From: [Garry Greetham](#)
To: [Sargeson, Bradley \(PLANNING OFFICER\)](#)
Subject: RE: 2024/0012 - 8 Allendale Road
Date: 09 February 2024 09:02:12
Attachments: [image001.png](#)

From: Sargeson , Bradley (PLANNING OFFICER) <BradleySargeson@barnsley.gov.uk>
Sent: 08 February 2024 09:47
To: Garry Greetham <garry@garrygreethamassociates.co.uk>
Subject: 2024/0012 - 8 Allendale Road

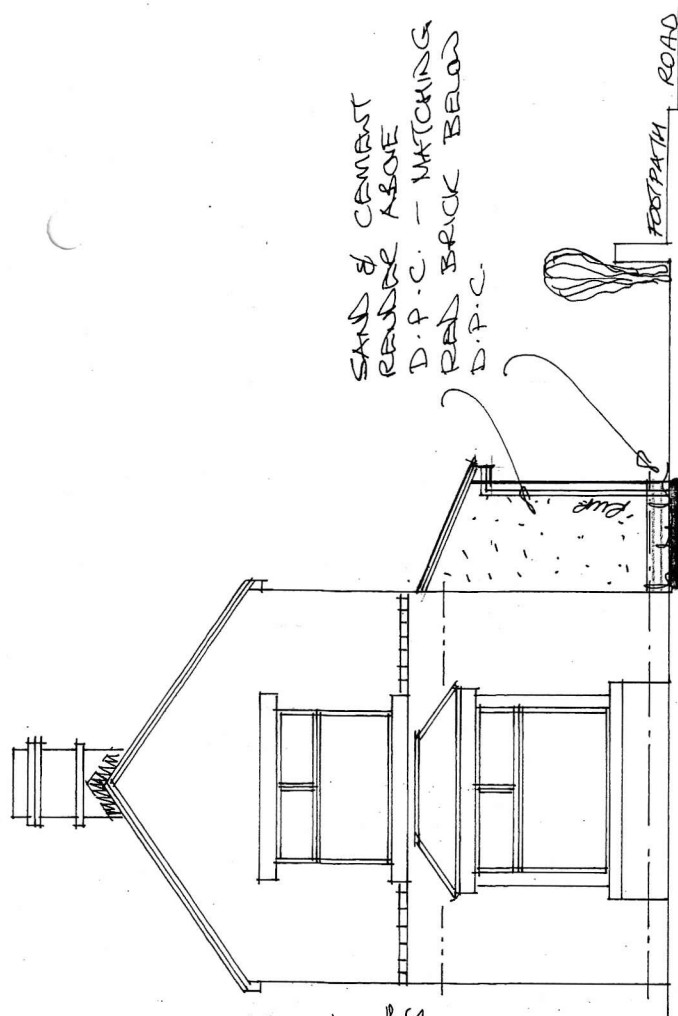
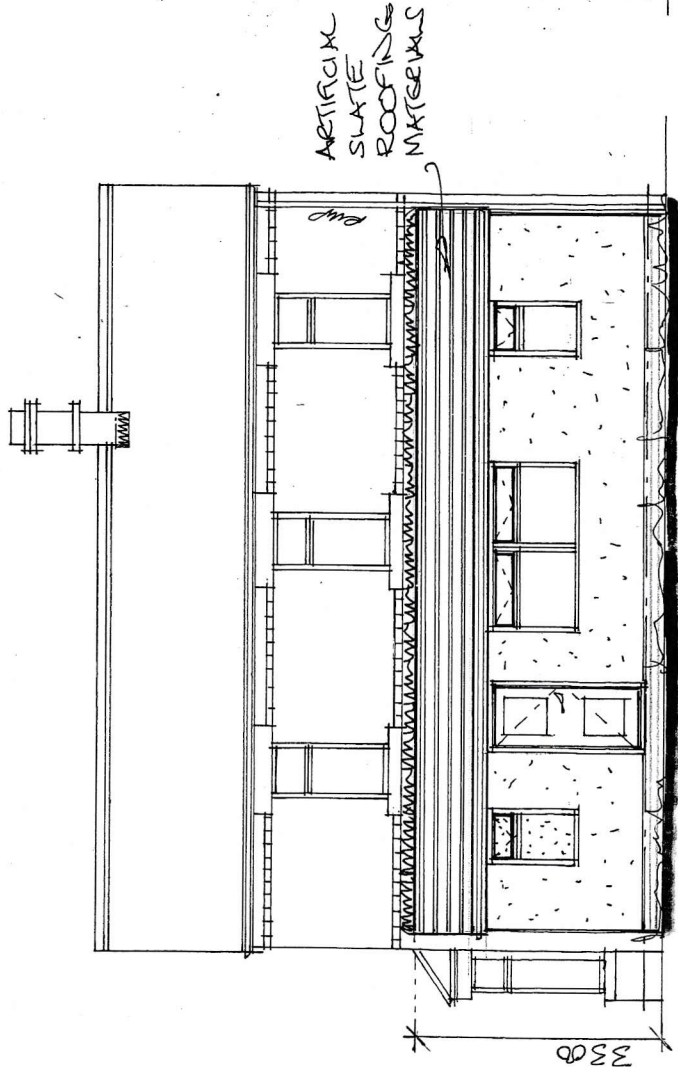
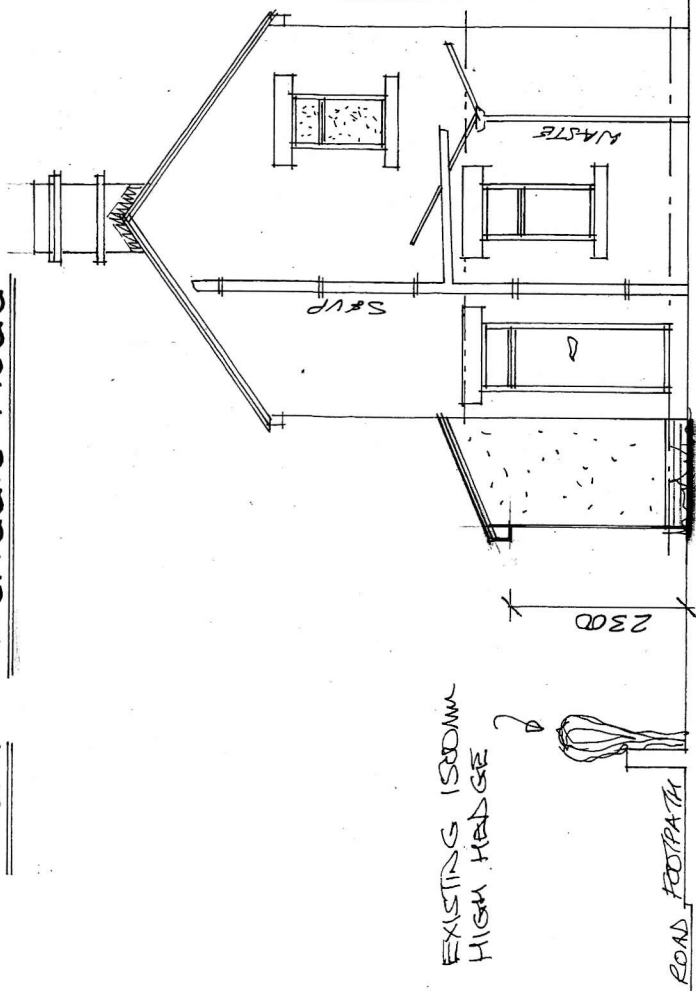
After reviewing the proposals and visiting the site yesterday, I have no issue with principle of the development. However, I would ask for further clarification and detail regarding external materials. Are you able to provide example images or links for the roofing materials and the colour of the render?

- i) Roofing – black coloured artificial slate effect tiles and
- ii) Render – 15 / 20mm sand and cement render with “off white” colour masonry paint or “one coat colour” render by specialist – again off white colour.
